CITY OF ALBUQUERQUE

November 19, 2024

Re: Panda Express
261 98th St NW
30-Day Temporary Certificate of Occupancy
Transportation Development Final Inspection
Architect's Stamp dated 04-28-23 (K09-D038)
Certification dated 11-18-24

SITE PLAN

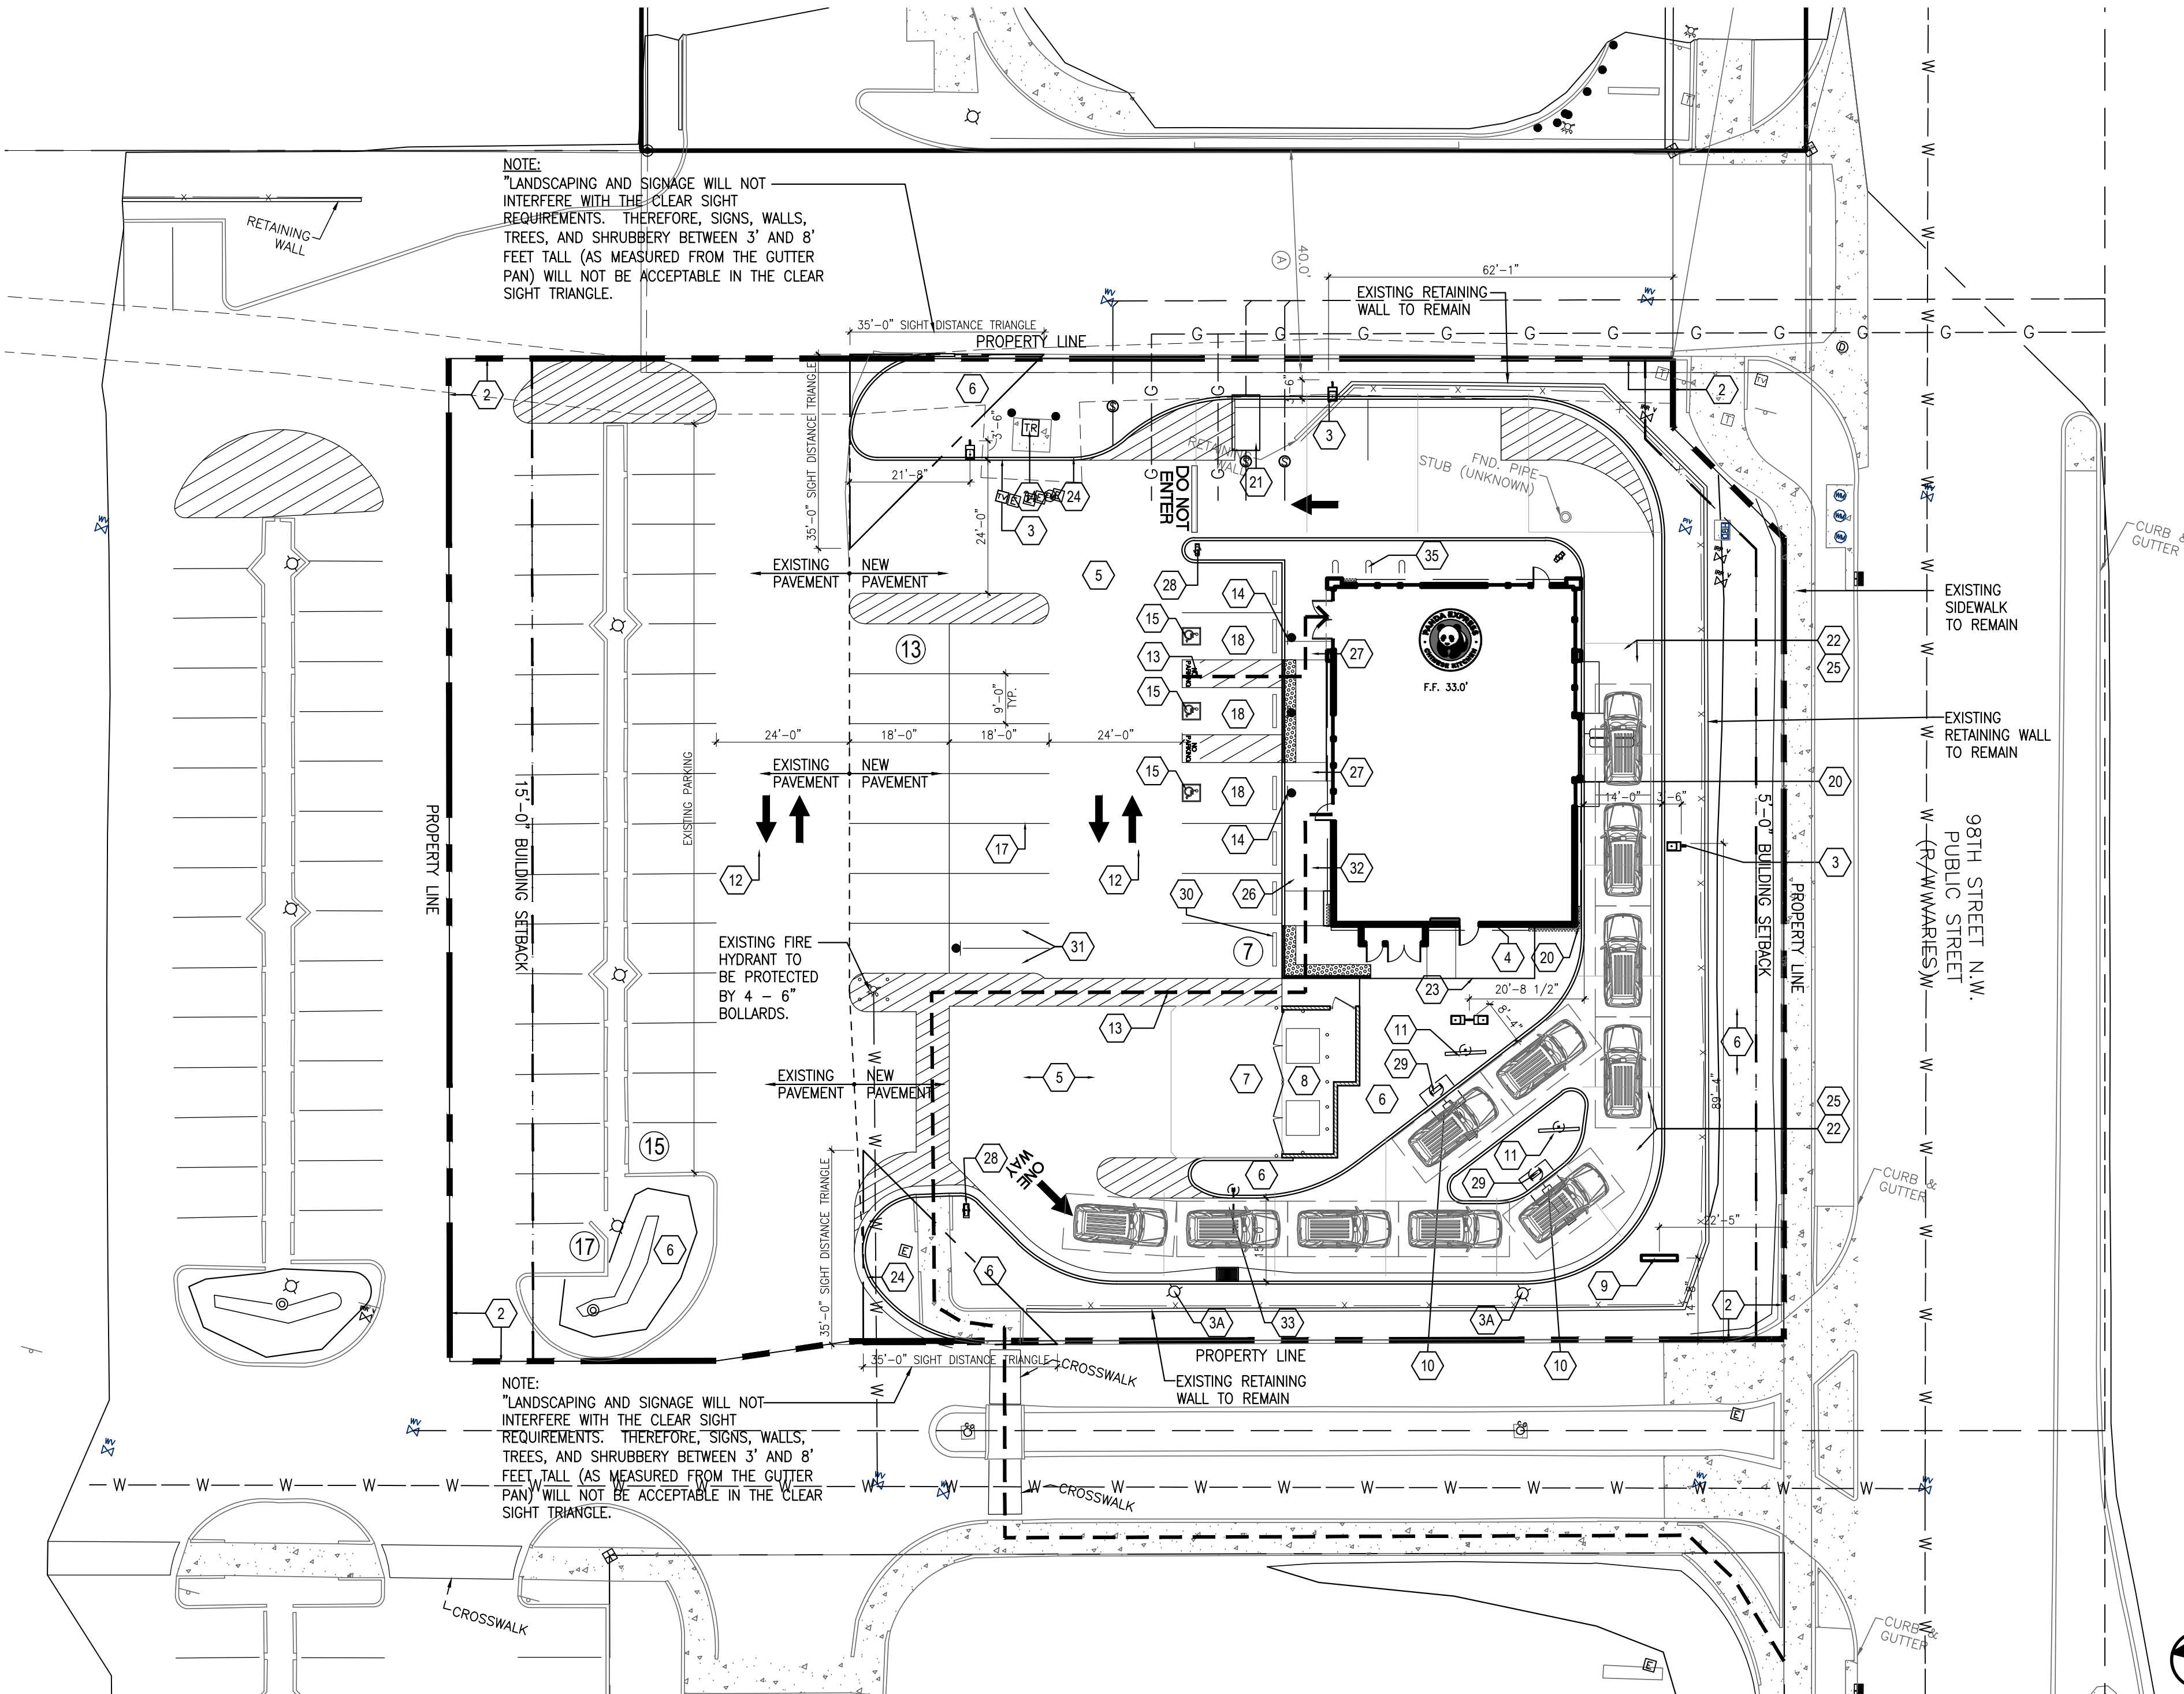
- Per the approved site plan the minimum ADA parking space width is 8.5 ft. per the site visit the width measured was 8 ft. ADA parking spaces must be upgraded to meet the current standard.

Once these corrections are complete, email pictures to malnajjar@cabq.gov for release of Final CO.
